June 29, 2023

RE: Sonic #1091
Southeast side of 98th St. and Bluewater Rd.
Traffic Circulation Layout

SITE PLAN

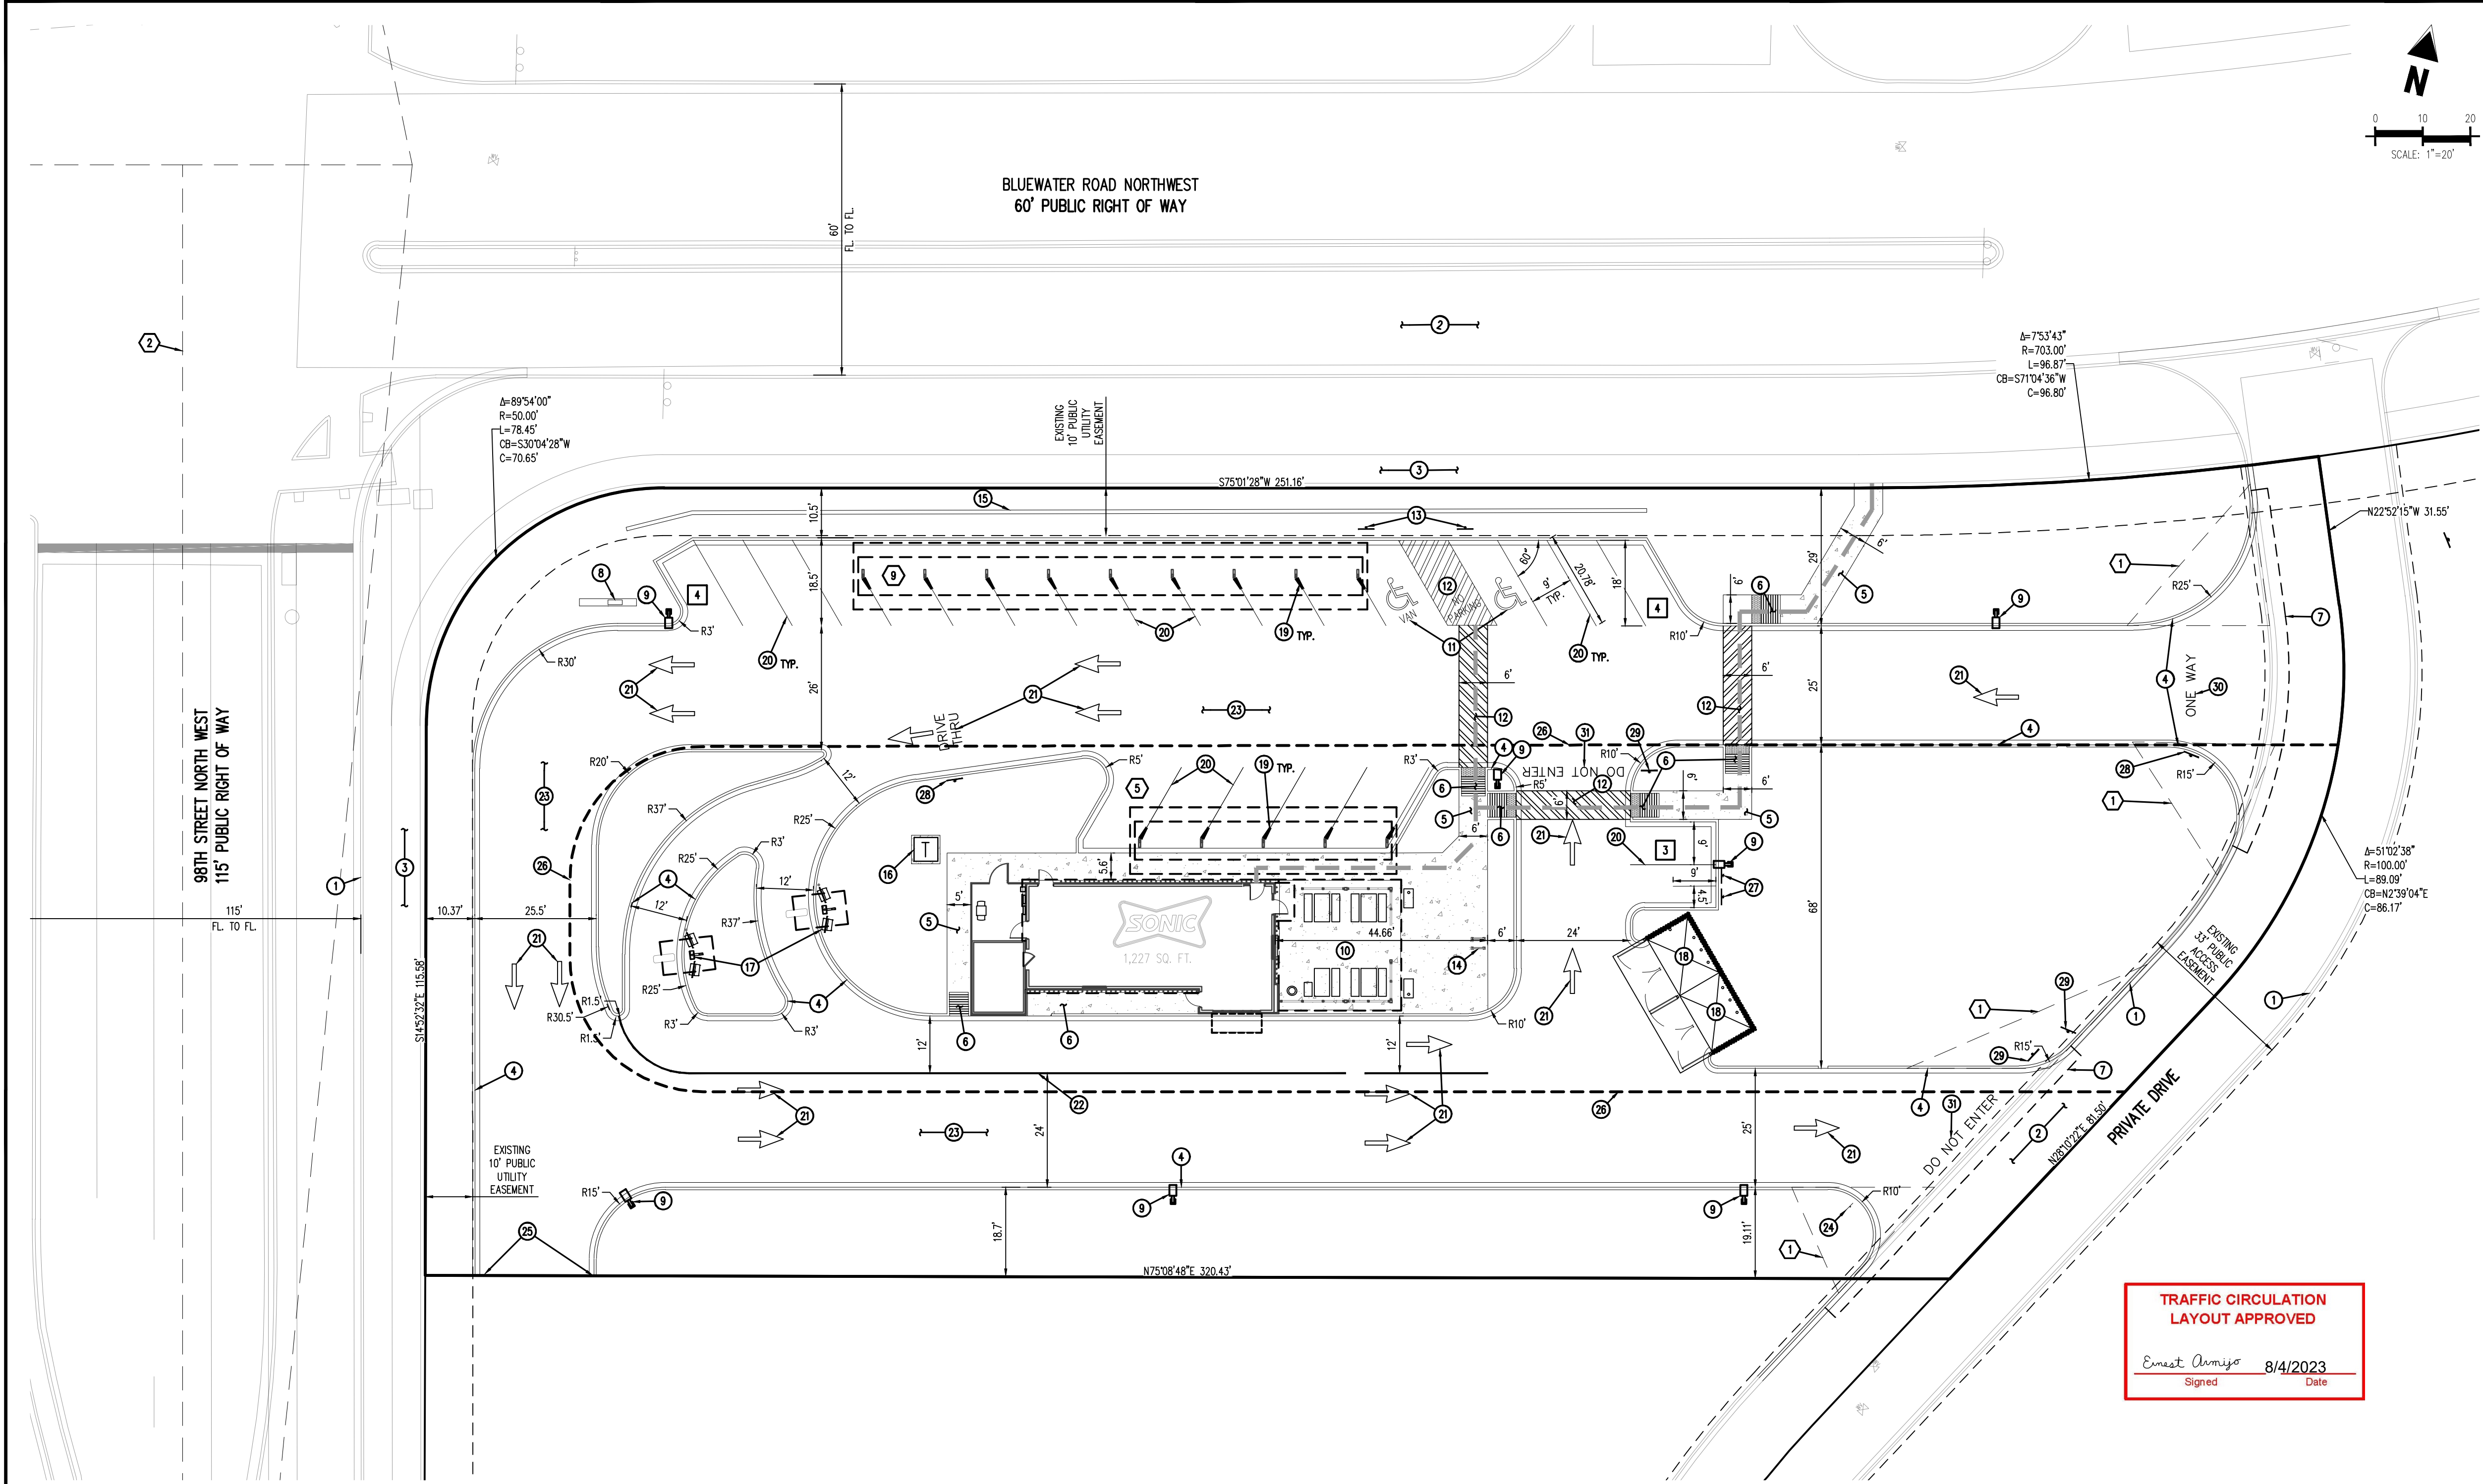
Response: The plans have been stamped and signed.
- 4) *Identify all existing access easements and rights of way width dimensions.*
Response: Access easements and ROW dimensions have been added.

- 5) *Please define the property line.*
Response: Property line has been thickened.
- 6) *Provide shared access agreement or approved plat showing the existing 33' access easement at the east side of the site.*

Response: The final plat has been included in this submittal.
- 7) *Provide the angle for the angled parking. See attached angle parking stall requirements.*

Response: Angle dimension has been added.
- 8) *Provide details for all the proposed interior ADA ramp.*
Response: Ramp details have been added.
- 9) *The ADA accessible parking sign must have the required language per 66-7-352.4C NMSA 1978 "Violators Are Subject to a Fine and/or Towing." Please call out detail and location of signs.*

- 10) *The ADA access aisles shall have the words "NO PARKING" in capital letters, each of which shall be at least one foot high and at least two inches wide, placed at the rear of the parking space so as to be close to where an adjacent vehicle's rear tire would be placed. (66-1-4.1. B NMSA 1978)*

- 11) *ADA curb ramps must be updated to current standards and have truncated domes installed.*

Response: Fire Marshal approval has been included.
- 23) *All one-way drives shall have "One Way" and "Do Not Enter" signage and pavement markings. Please show detail and location of posted signs and striping.*

Response: Signage and sign details have been added.
- 24) *The minimum drive through lane width is 12 feet with a 25-foot minimum radius (inside edge) for all turns. (A 15-foot radius can be used with an increase in lane width to 14 feet). Please dimension all lane widths and radii.*

Response: Drive thru lanes expanded.
- 25) *Show on the site plan the Intersection clear sight triangle at the intersection of 98th St. and Bluewater rd.*

Response: Sight triangles added.
- 26) *Show the clear sight triangle and add the following note to the plan: "Landscaping and signage will not interfere with clear sight requirements. Therefore, signs, walls, trees, and shrubbery between 3 and 8 feet tall (as measured from the gutter pan) will not be acceptable in the clear sight triangle.*

Response: Location of signs and a detail have been added to the plan.

Response: Lettering added.

Response: Ramps have been updated.
